Our ref: SSD 8922

**Major alterations and additions to the Stevenson Library Building (SSD 8922)
Scots College, 29-53 Victoria Road, Bellevue Hill – Response to Submissions**

Figure 1 Construction Management Plan DIAGRAM

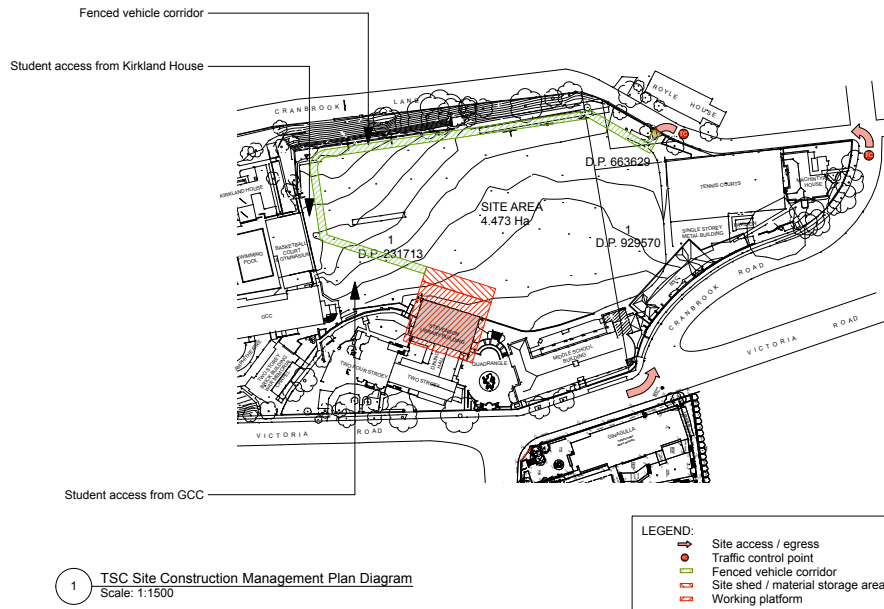
To mitigate construction traffic and parking issues, consideration must be given to the provision of parking for all construction staff on site on the oval adjacent to the library building and construction area. This would be in addition to the mitigation measures outlined in section 6.11 of the parking and traffic assessment provided by PTC dated 25th June 2018.
